30 October 2018

16734

RE: PICTON HIGH SCHOOL REDEVELOPMENT (SSD 17_8640) RESPONSE TO SUBMISSIONS

Project Name	PICTON HIGH SCHOOL REDEVELOPMENT PICTON, NSW 2571
Drawing Title	ARGYLE STREET TRAFFIC CONTROL DEVICE SKETCH PLAN

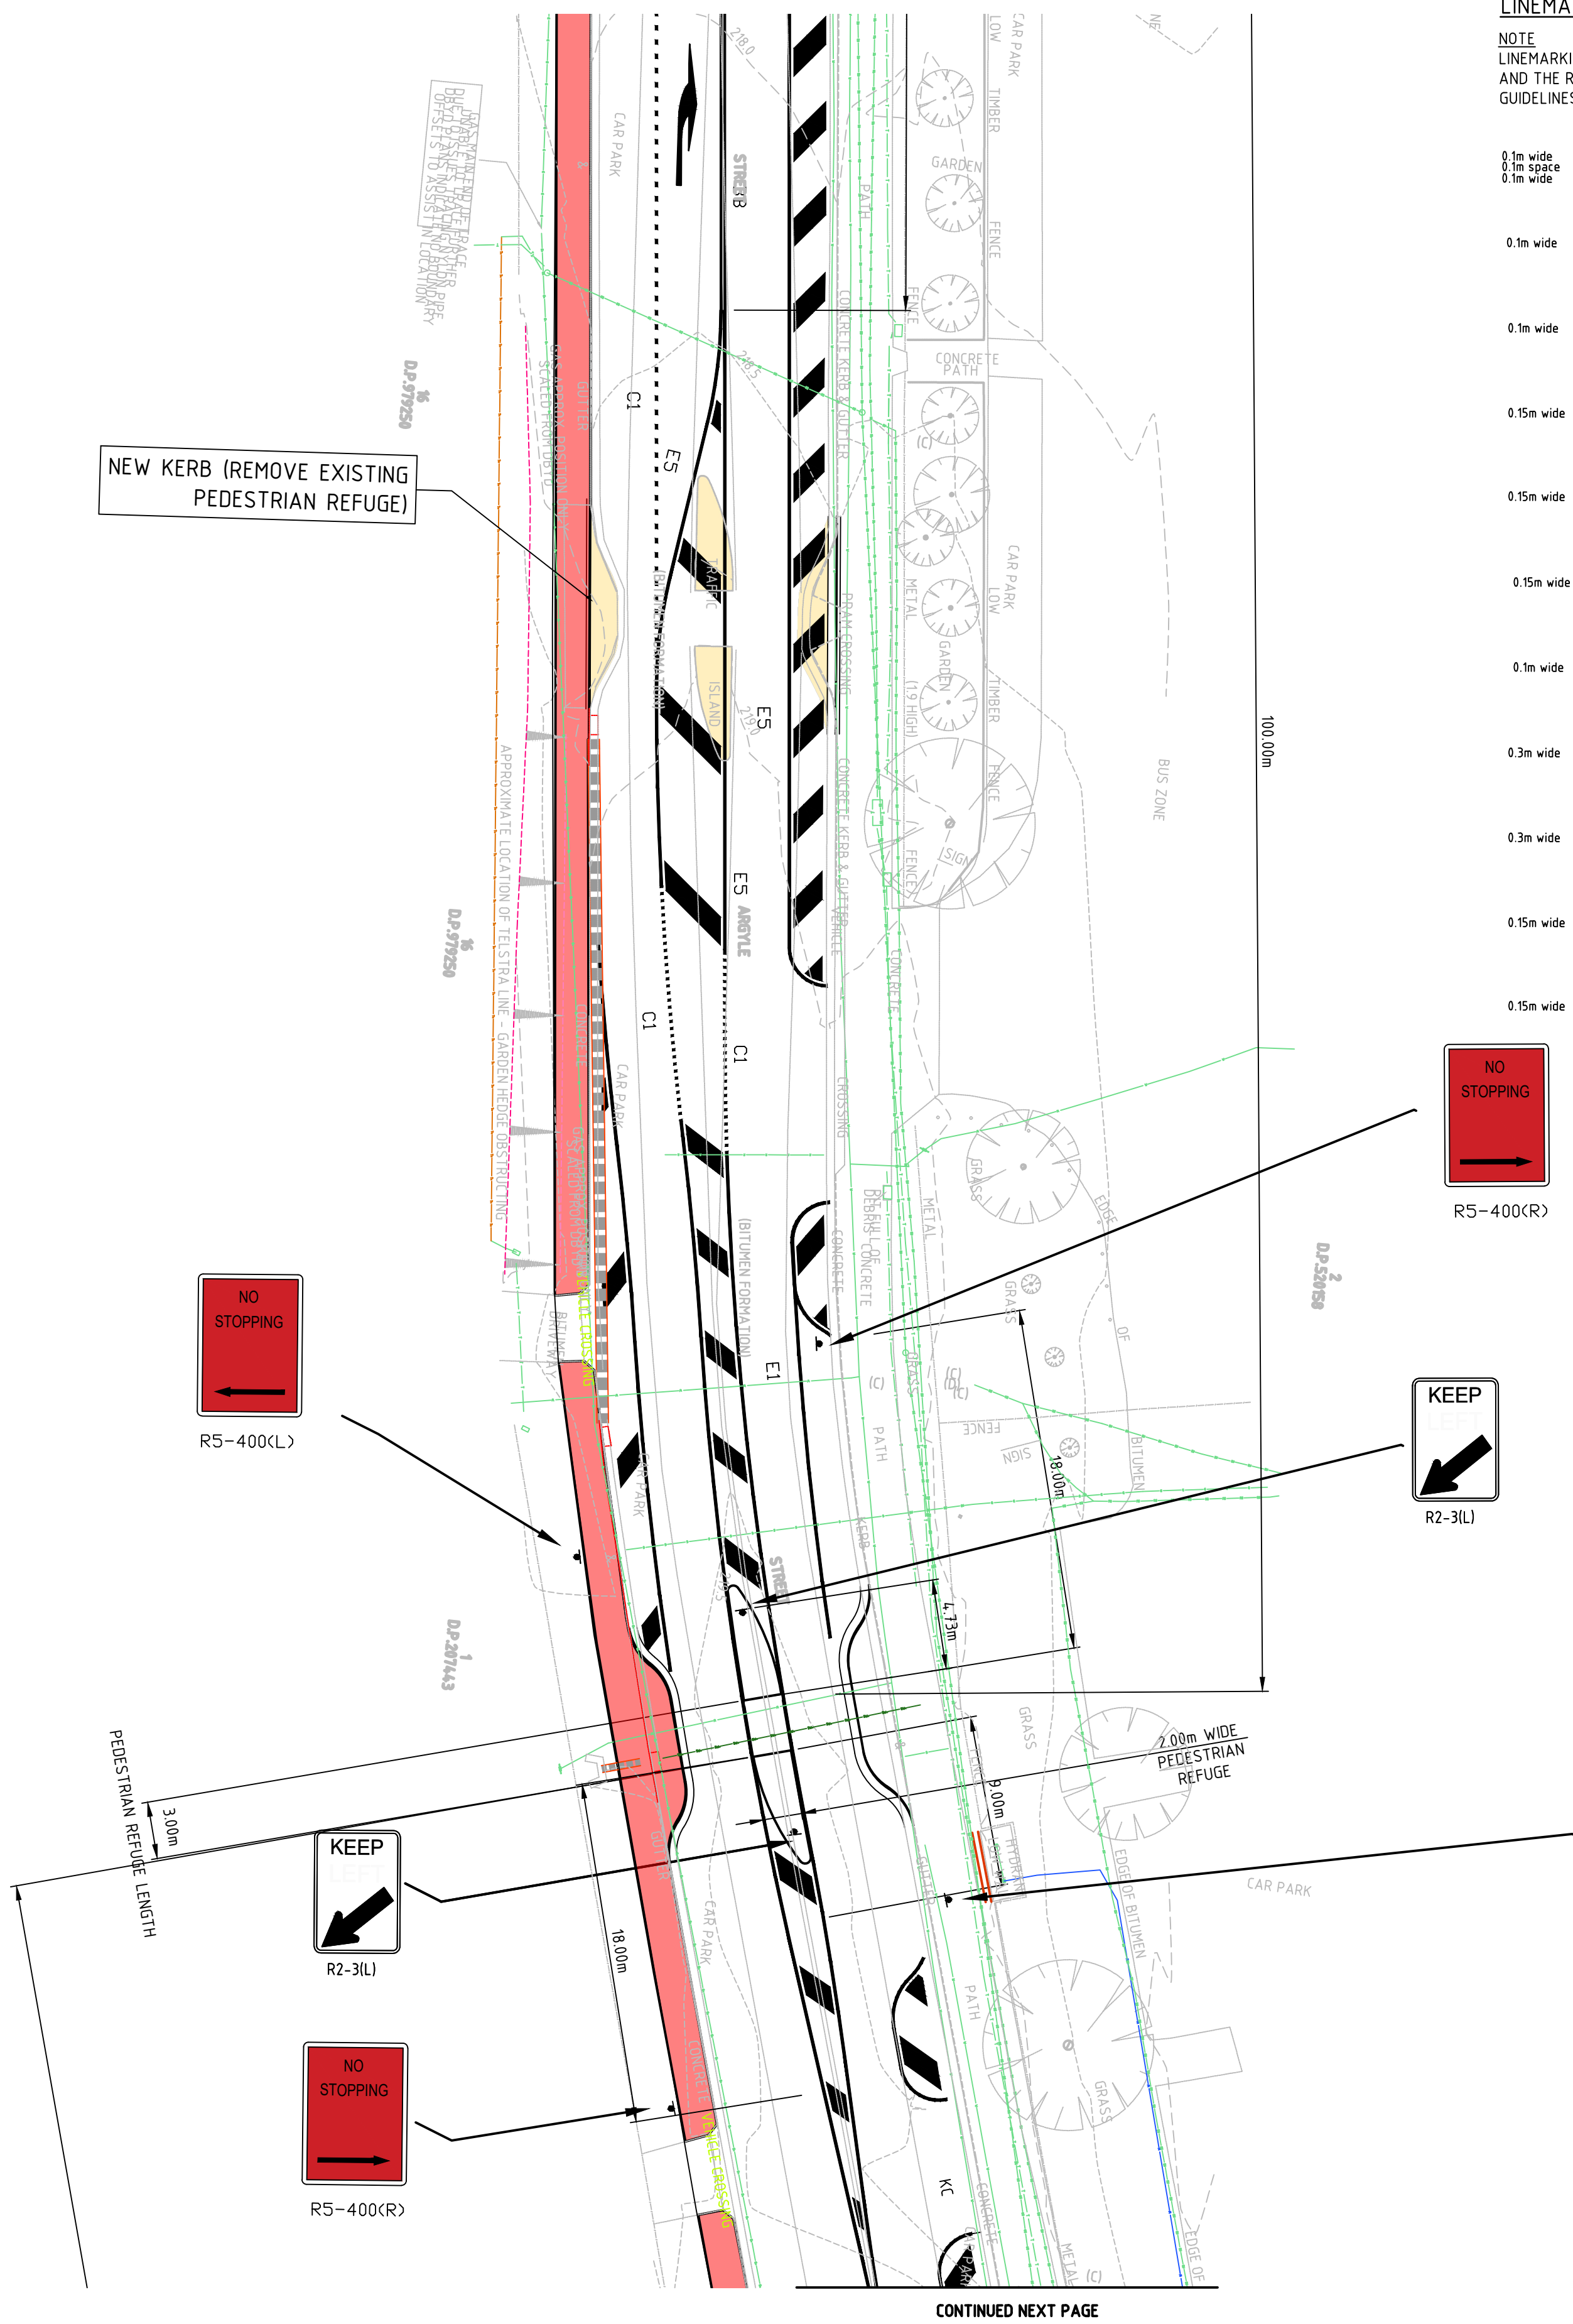
Roads and Maritime Services have requested that conceptual plans for the proposed works on Argyle Street should contain a greater level of detail to demonstrate compliance with relevant standards. This would enable assessment of impacts and compliance with applicable Austroads requirements. Drawings demonstrating greater detail regarding transport, road, footpath and infrastructure considerations is provided at **Attachment O**.

Picton High School
Swept Path Assessment
On-site Bus Parking

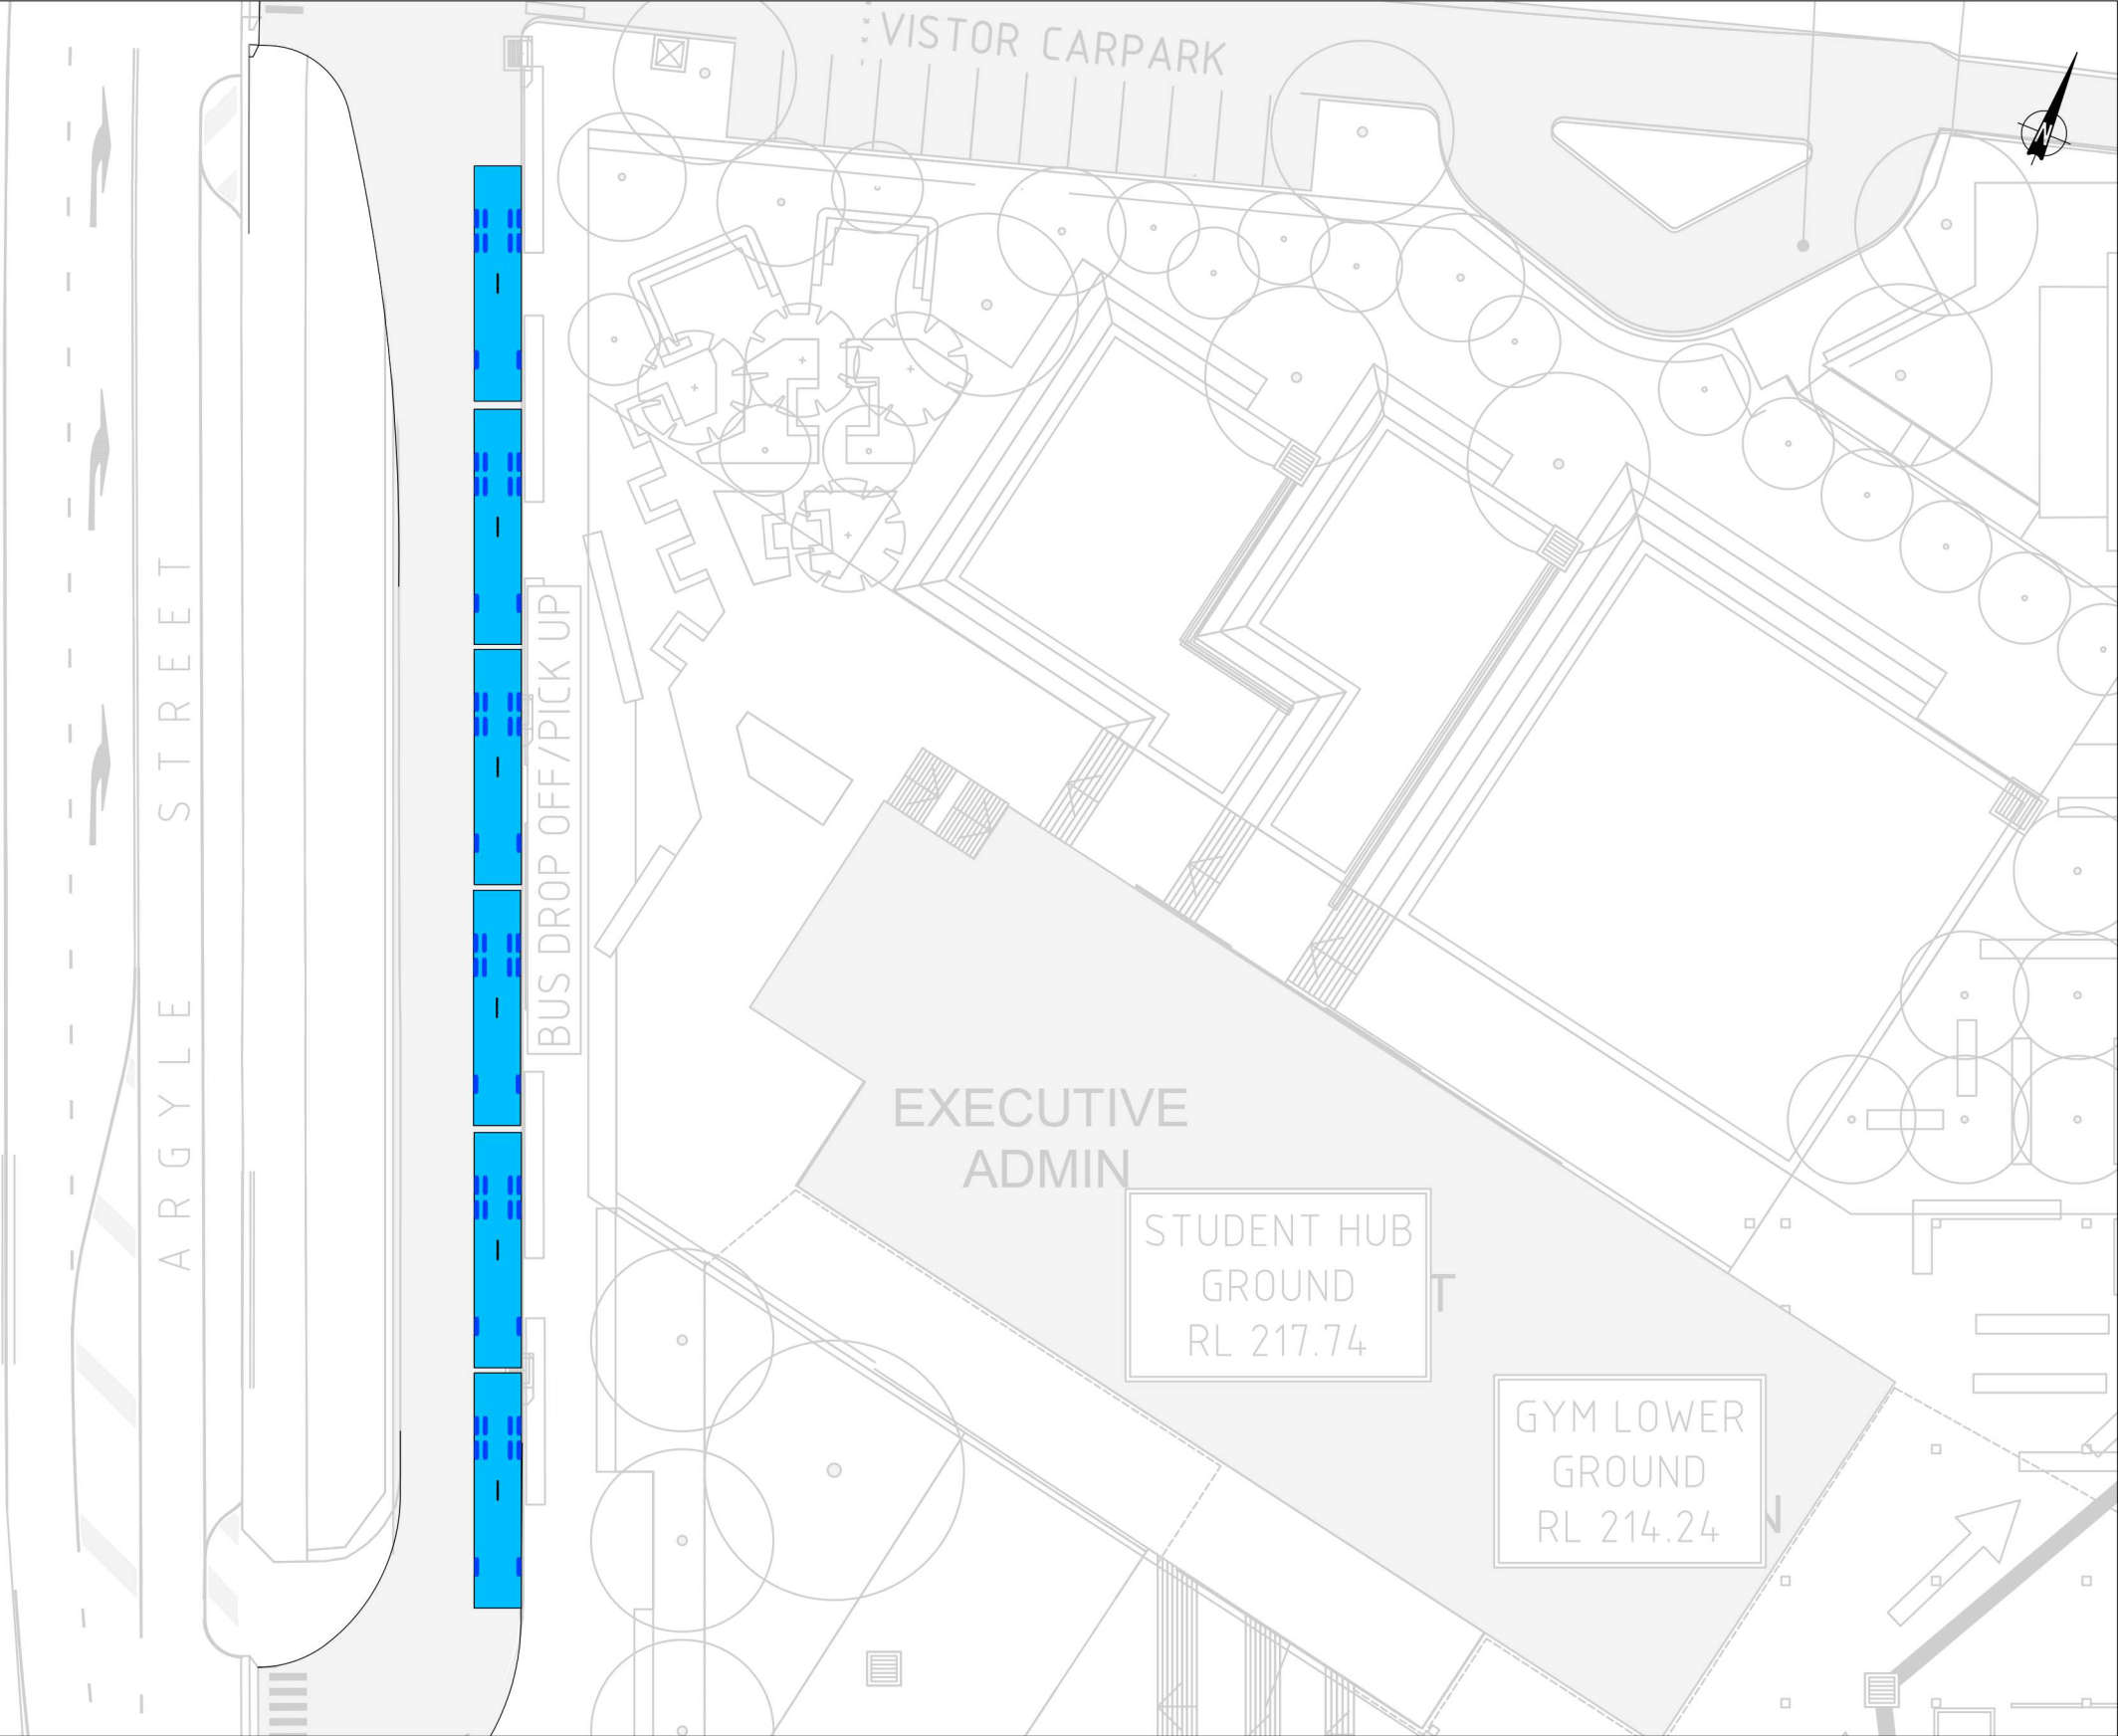
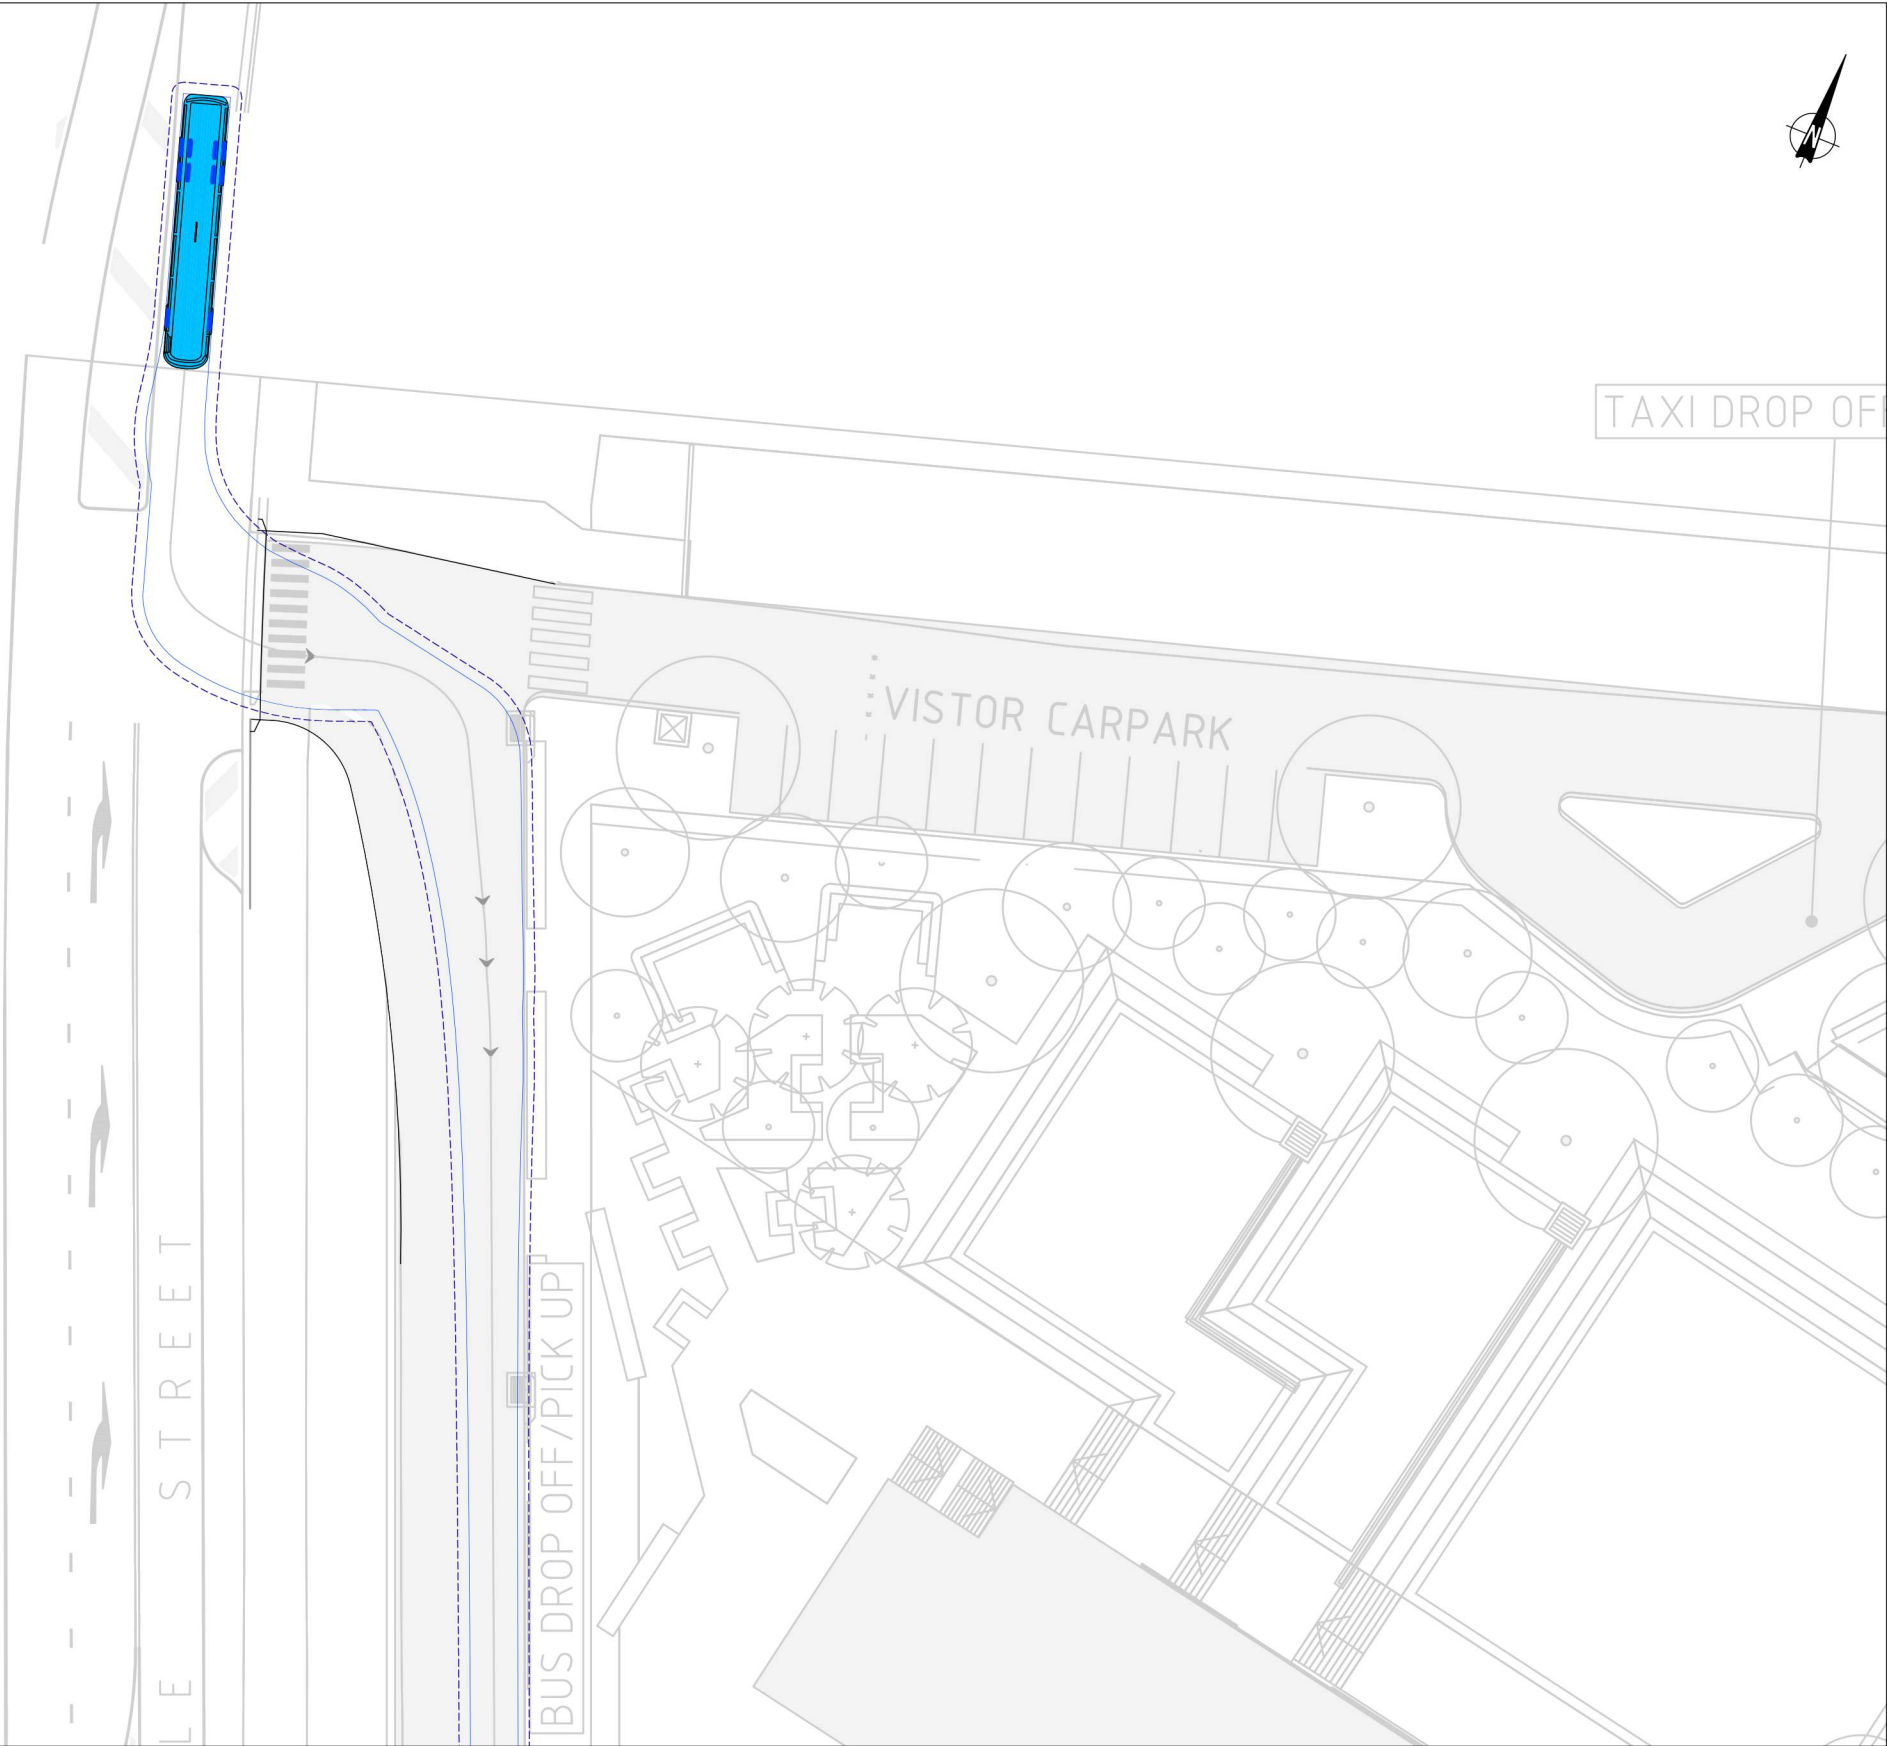
- An assessment of buses exiting the site whilst a bus is parked in the southernmost bus parking bay. In order for a bus to be able to exit the site in this arrangement it is recommended that the kerb line be amended as shown within the relevant figures.

- An assessment of buses accessing the site whilst a bus is parked in the northernmost bus parking bay. The assessment shows that a bus accessing the site from the north can access the site in this arrangement with some modification to the kerb line. However, a bus accessing the site from the south would be required to wait for the bus to exit the bus bay. In this event, the bus would be able to wait on-site or within the right turn bay. To maintain a narrow crossover width at the northern site access to ensure pedestrian safety, and given the infrequent nature of this event occurring, and the low impact of buses waiting for a short period of time before accessing the bus bay, this arrangement is considered to be acceptable.

Accordingly, it is the kerb line has been amended as per the swept path diagrams, as shown in **Figure 1** below.

These proposed recommendations have been made to the architectural drawings at **Attachment B**.
